CITY OF PORTLAND, MAINE  
DEVELOPMENT REVIEW APPLICATION  
PLANNING DEPARTMENT PROCESSING FORM

Rabbit Run (32) lot #21

**CITY OF PORTLAND, MAINE  
SITE PLAN REVIEW (ADDENDUM)  
CONDITIONS OF APPROVAL**

APPLICANT: HILDAETH & WHITE  
 ADDRESS: P.O. Box 8433, PORTLAND ME 04104  
 SITE ADDRESS/LOCATION: 32 RABBIT RUN Lot 21  
 DATE: 6/8/98

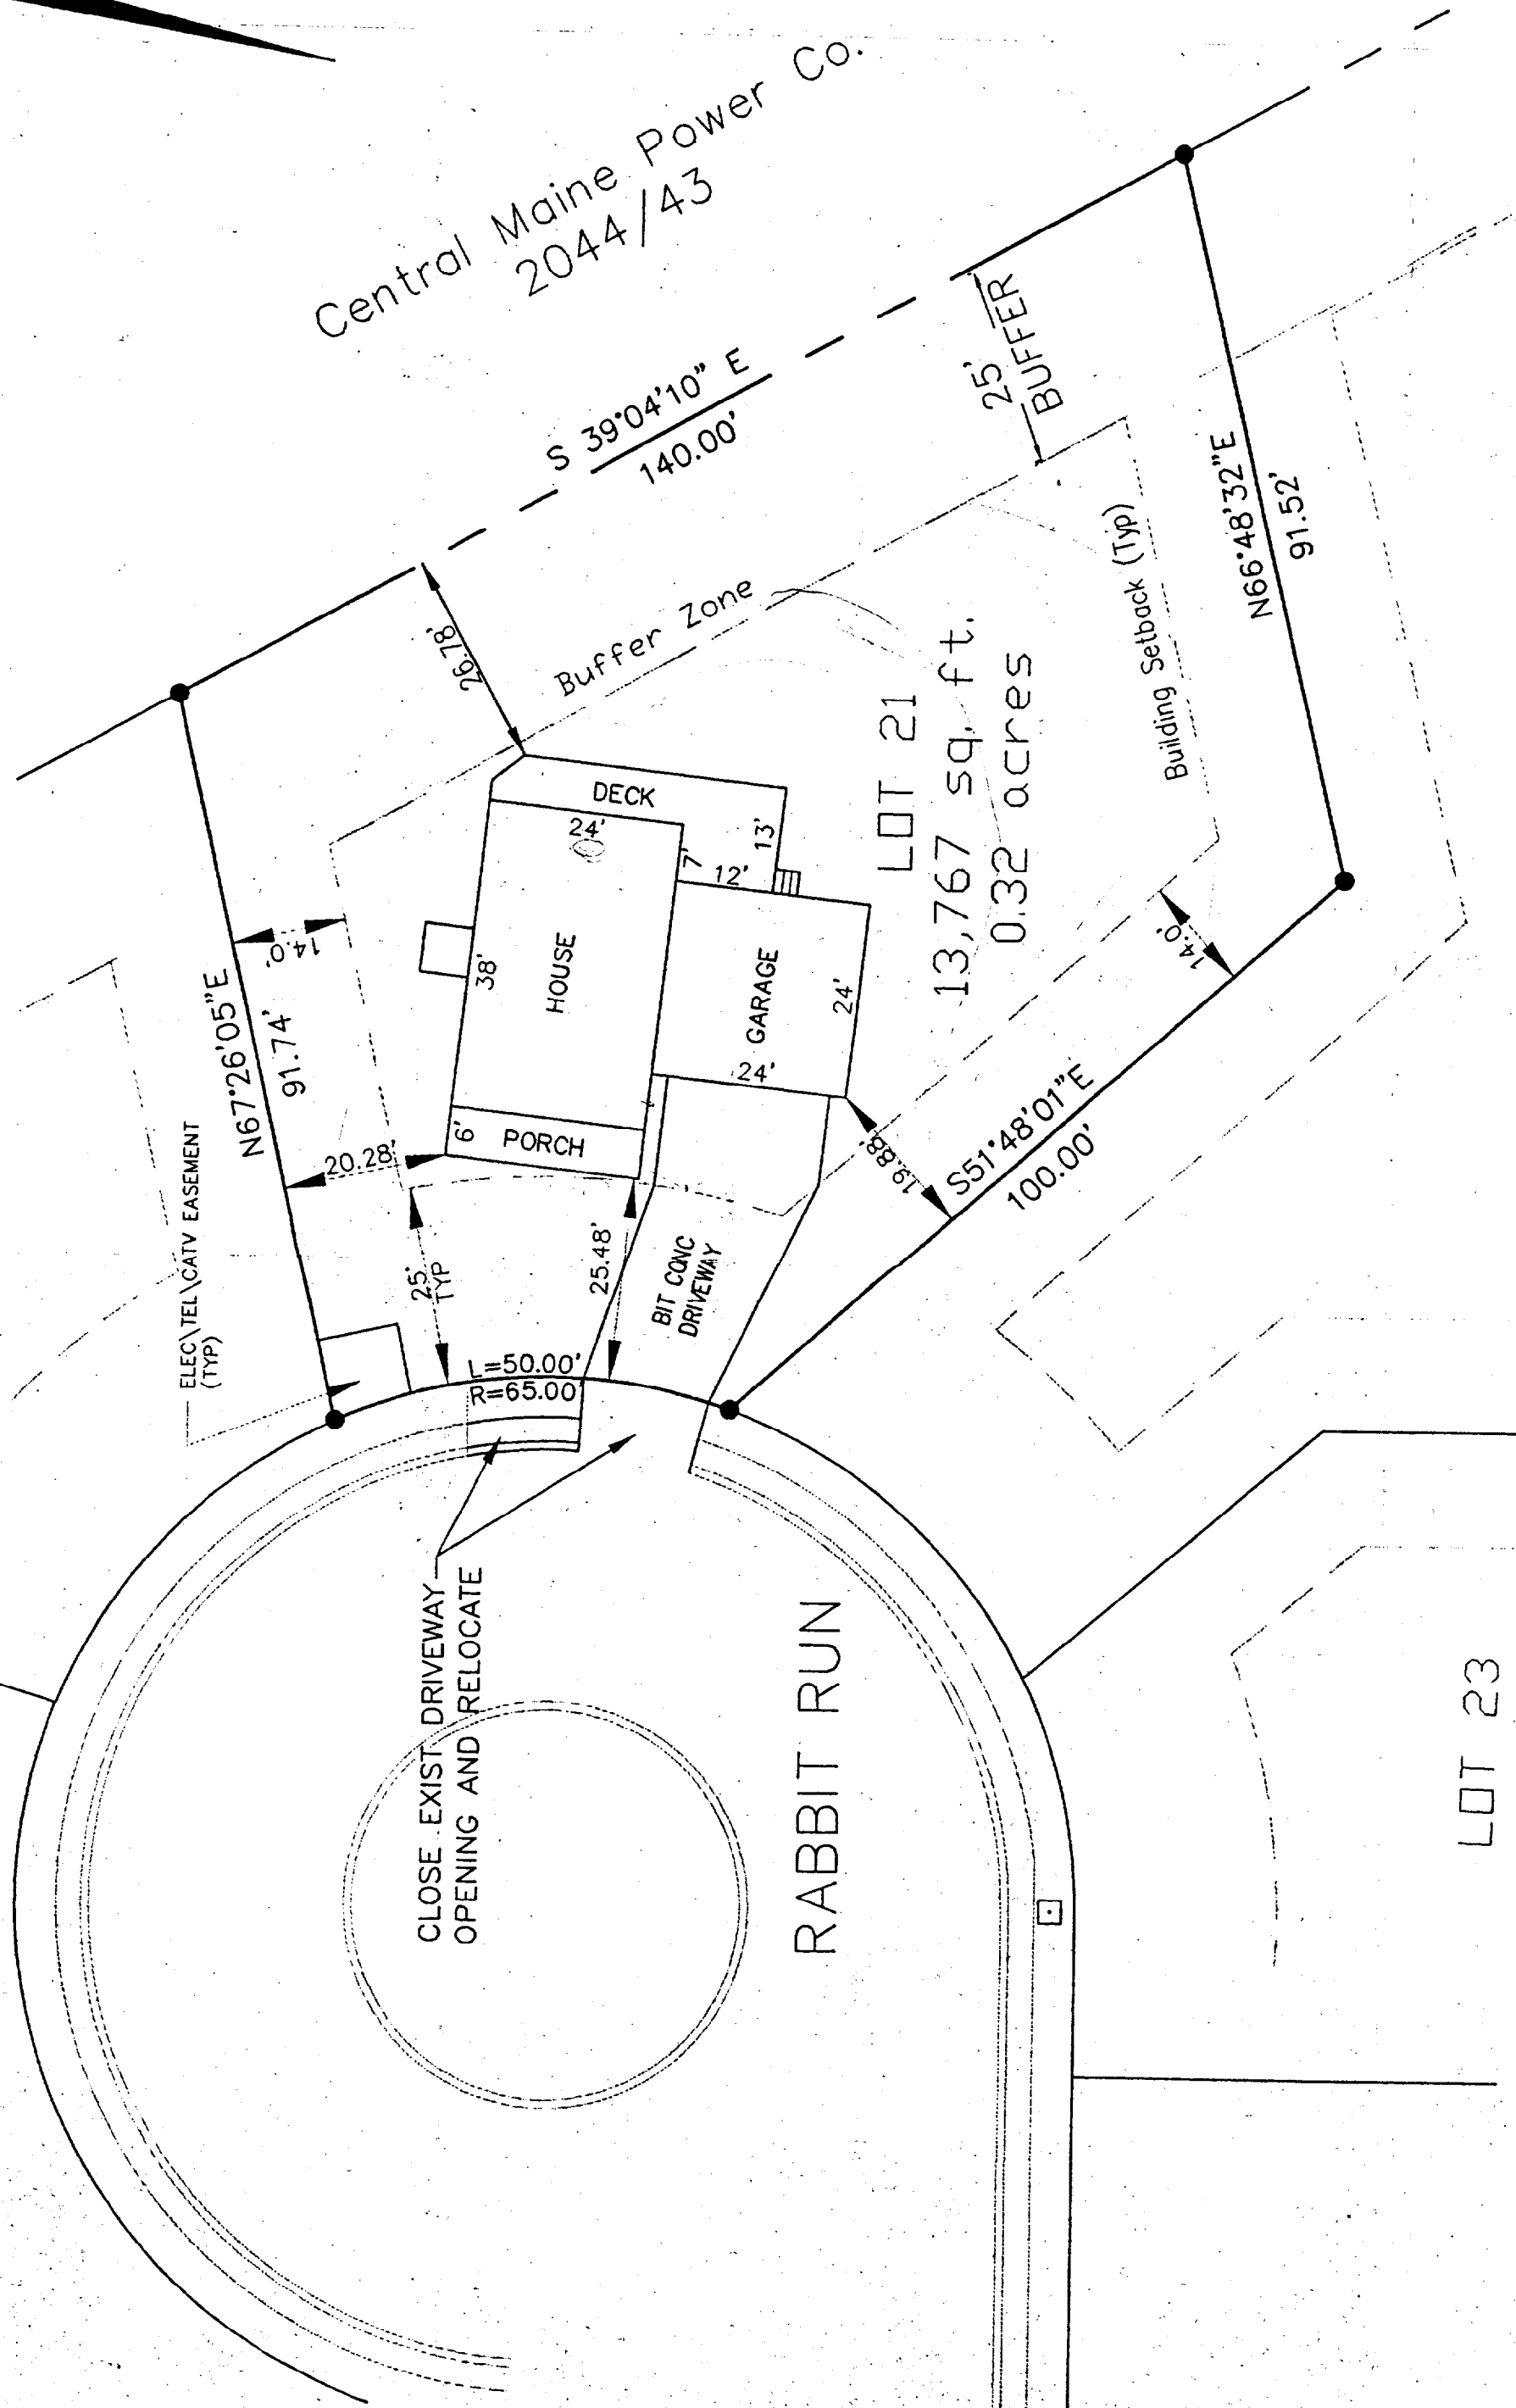
5. ☒ Show all utility connections: water, sanitary sewer, storm drain, electric, telephone, cable.
6. ☒ A sewer permit is required for your project. Please contact Carol Merritt at 874-8300, ext. 8828. The Wastewater and Drainage section of Public Works must be notified five (5) working days prior to sewer connection to schedule an inspector for your site.

11. ☒ A drainage plan shall be submitted to and approved by Development Review Coordinator showing first floor elevation (FEE), sill elevation (SE), finish street/curb elevation, lot grading, existing and proposed contours, drainage patterns and paths, drainage swales, grades at or near abutting property lines, erosion control devices and locations and outlets for the drainage from the property.

13. ☒ EMBEDD SOIL SHALL BE CONTAINED ON  
SITE. A CRUSHED STONE CONSTRUCTION  
ENTRANCE SHALL BE PLACED AT THE  
EXISTING CURB CUT.  
SILT FENCE SHALL BE INSTALLED

DOWN GRADIENT OF DISTURBED AREA  
TO PROTECT THE BUFFER ALONG THE  
BACK OF THE LOT.
